RE: Planning Ref: PAX19.323579 – Proposed Windfarm development of 7 Turbines, 110kV substation and associated works within the townlands of Leitrim, Lumville, Ballinla, Clarkeville, Ballyfore Big, Ballyfore Little, Ballyeakin and Ballykilleen, in (Coolestown By) Co. Offaly (www.ballinlawindfarmsid.ie)

Ballinla Proposed Wind Farm Proximity to BnM Landbank

DRWG No. BNM-PG-25-19-01	Scale: 1:15,000	Drawn by: JG	Date: 23/10/2025
------------------------------------	---------------------------	------------------------	----------------------------

Figure 2-5: Proposed Wind Farm Layout

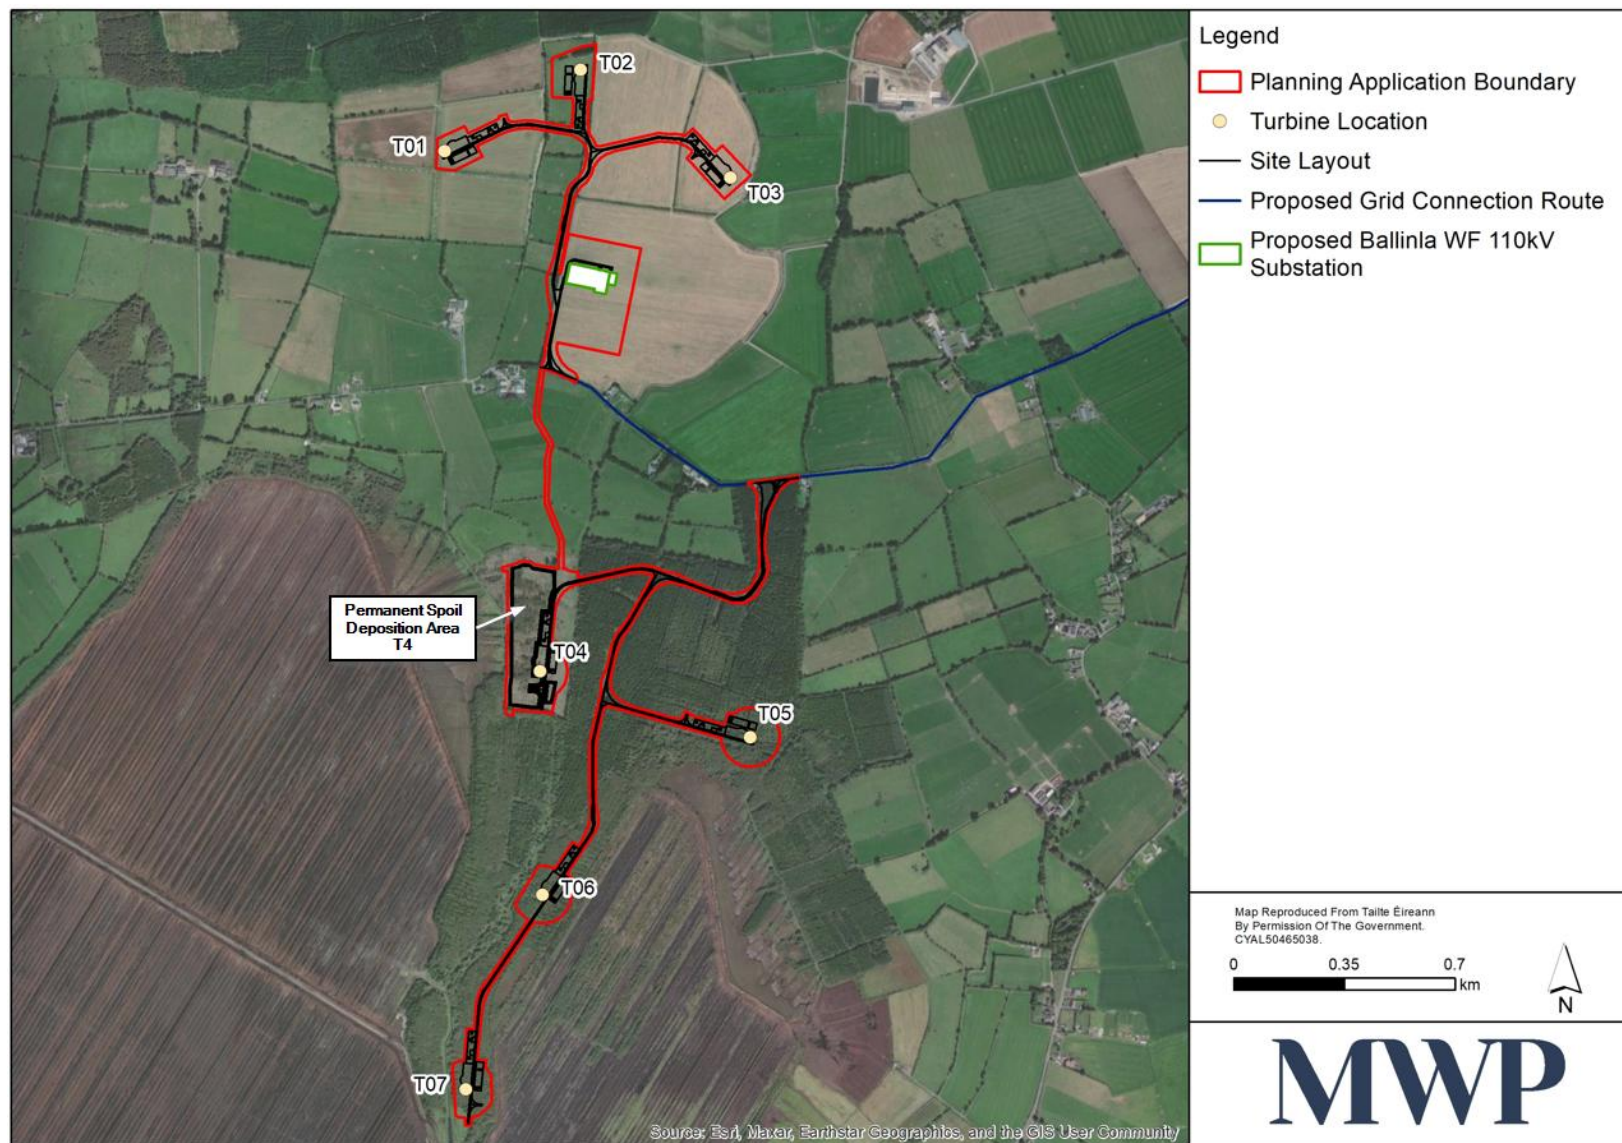
According to Section 5.13 of the *Wind Energy Development Guidelines* (DoEHLG, 2006), to protect adjoining land wind energy development potential and requirements for optimal performance “a distance of not less than two rotor blades from adjoining property boundaries will generally be acceptable, unless by written agreement of adjoining landowners to a lesser distance”. This was further clarified by the Department of

Environment, Heritage and Local Government (DEHLG) Circular Letter PD 6/16 that “*rotor blades are to be measured according to rotor diameter, and that a distance of not less than two rotor blades is therefore equivalent to two rotor diameters*”

The proposed maximum rotor diameter for Ballinla Wind Farm is 158.7m for all turbines. Best practice dictates a set-back of 317.4m (158.7m x 2) from each turbine to the adjoining land. Three turbines (T5, T6 and T7) are closer than the best practise guidance detailed above. Furthermore, (T5, T6 and T7) are within fall distance of BnM landbank, which creates a risk to BnM owned land during the operational life of the Wind Farm if consented. Please find attached drawing no: BNM_PG_25_19_01_ which demonstrates the turbine locations, an indicative 317.4m buffer applied around the turbines and the distance from the turbines to BnM landholding.

BnM has concerns as outlined above regarding the application of the Wind Energy Guidelines 2006 and the proximity of turbines to its landbank. It is on this basis that BnM respectfully request the consenting authority to examine the application, seek clarification if required and to apply the guidance in a consistent manner with respect to the proposed development.
